DRB Application No.: 03DRB-00092 (SBP)	Project # 1002435
Project Name: NORTH ALBUQ. ACRES UNIT B	EPC Application No.:
Agent: Dekker Perich Sabatini	Phone No.: 761-9700

CITY OF ALBUQUERQUE
Planning Department
Development Review Board Case Comments
1/29/03

Case # 03DRB-00092

Subject: North Albuquerque Acres, Unit B/ SDP for BP

SOUTH ELEVATION

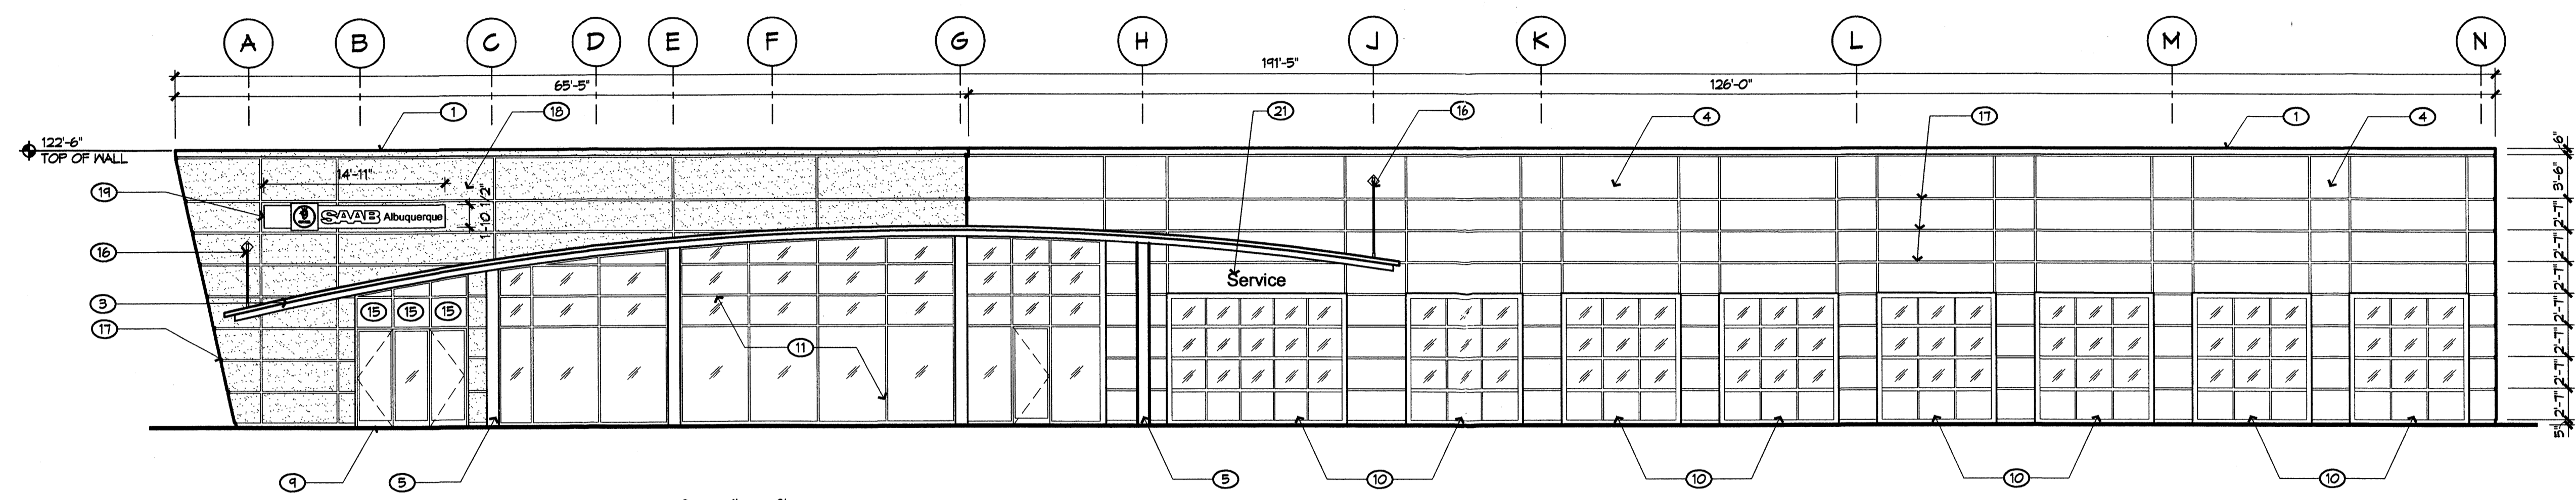
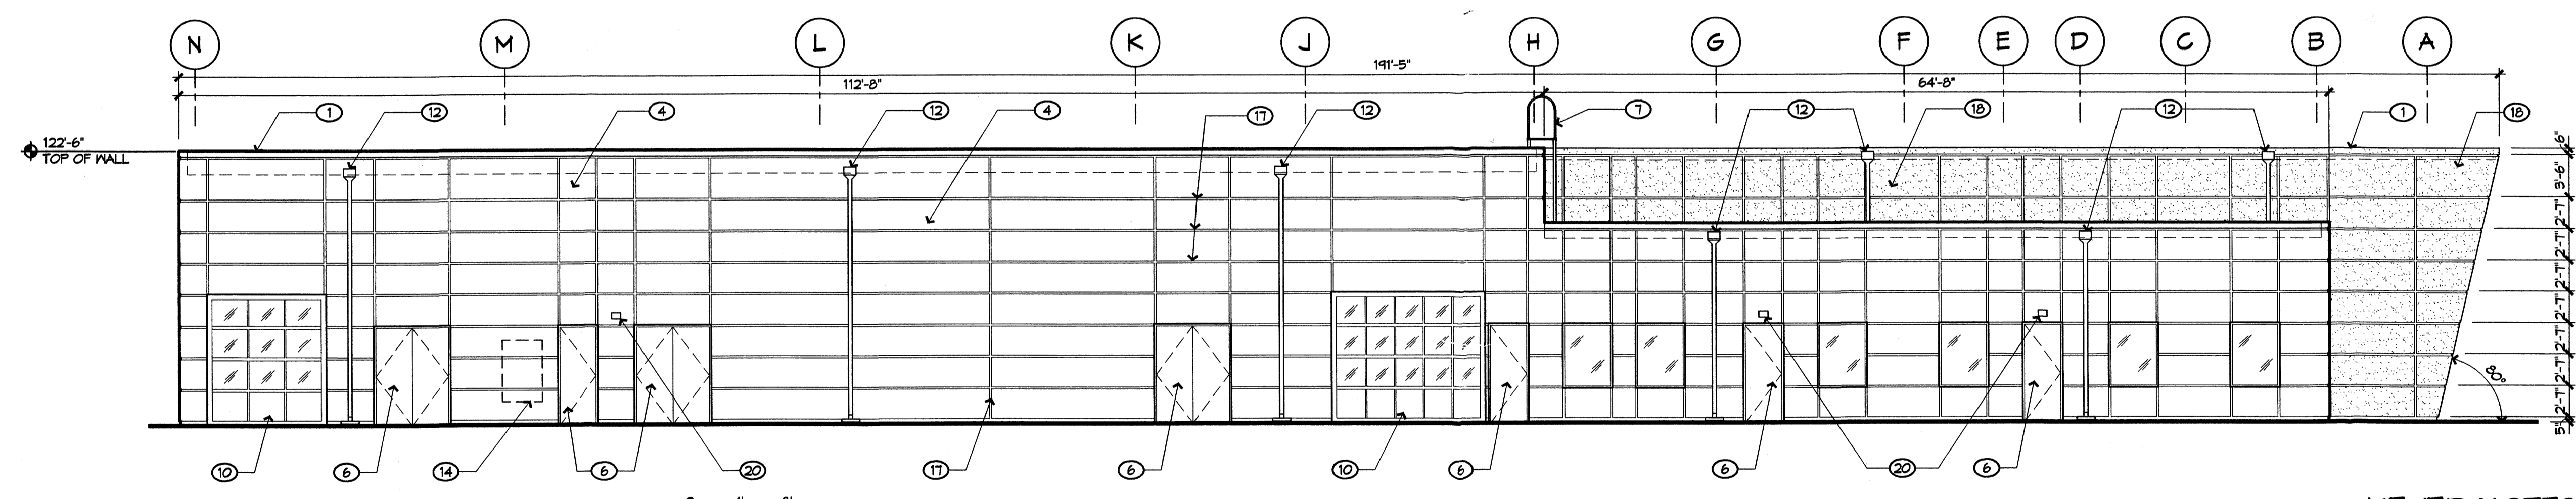
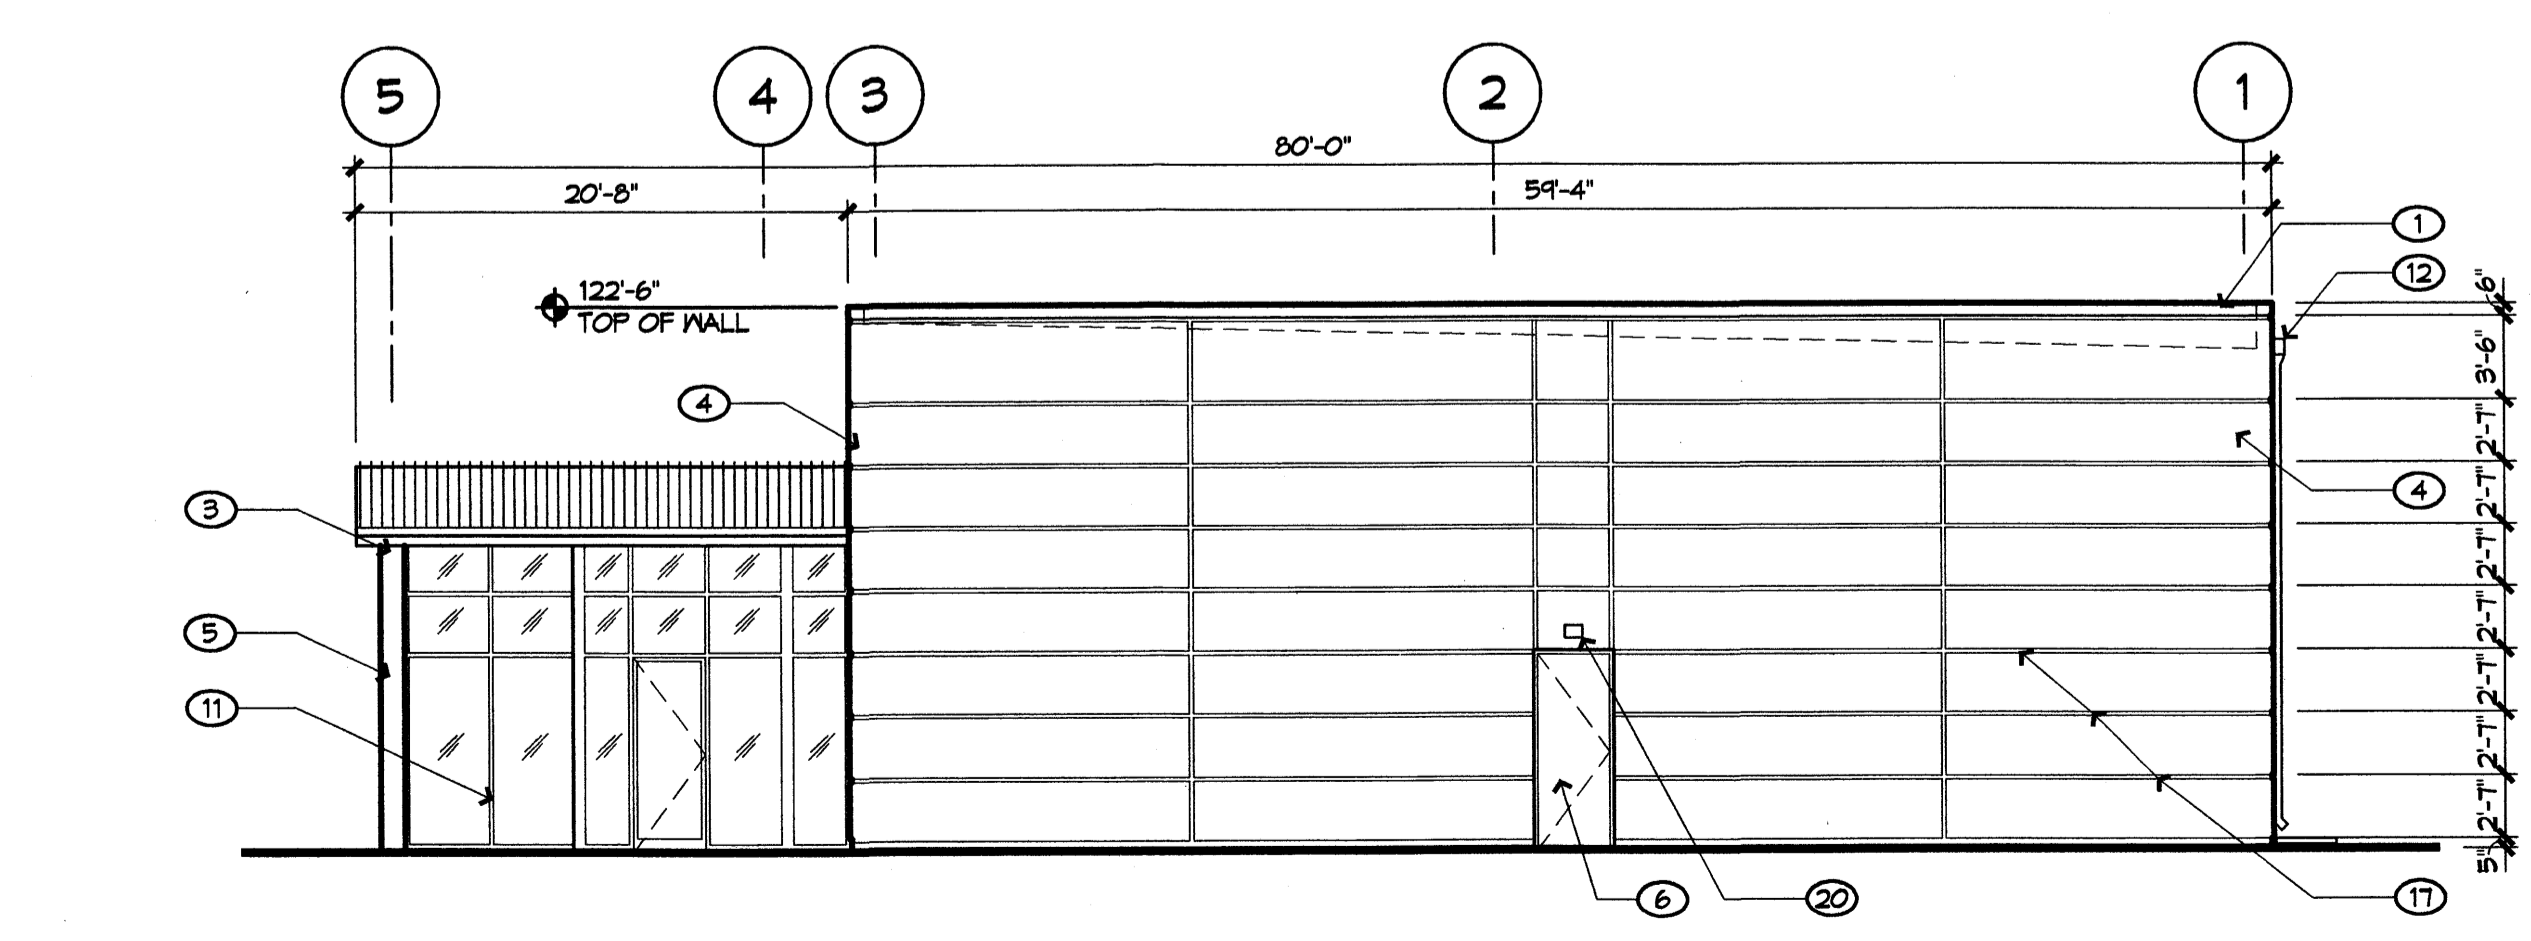
The elevations sheet does not show the building height. Please add that dimension to the sheet.
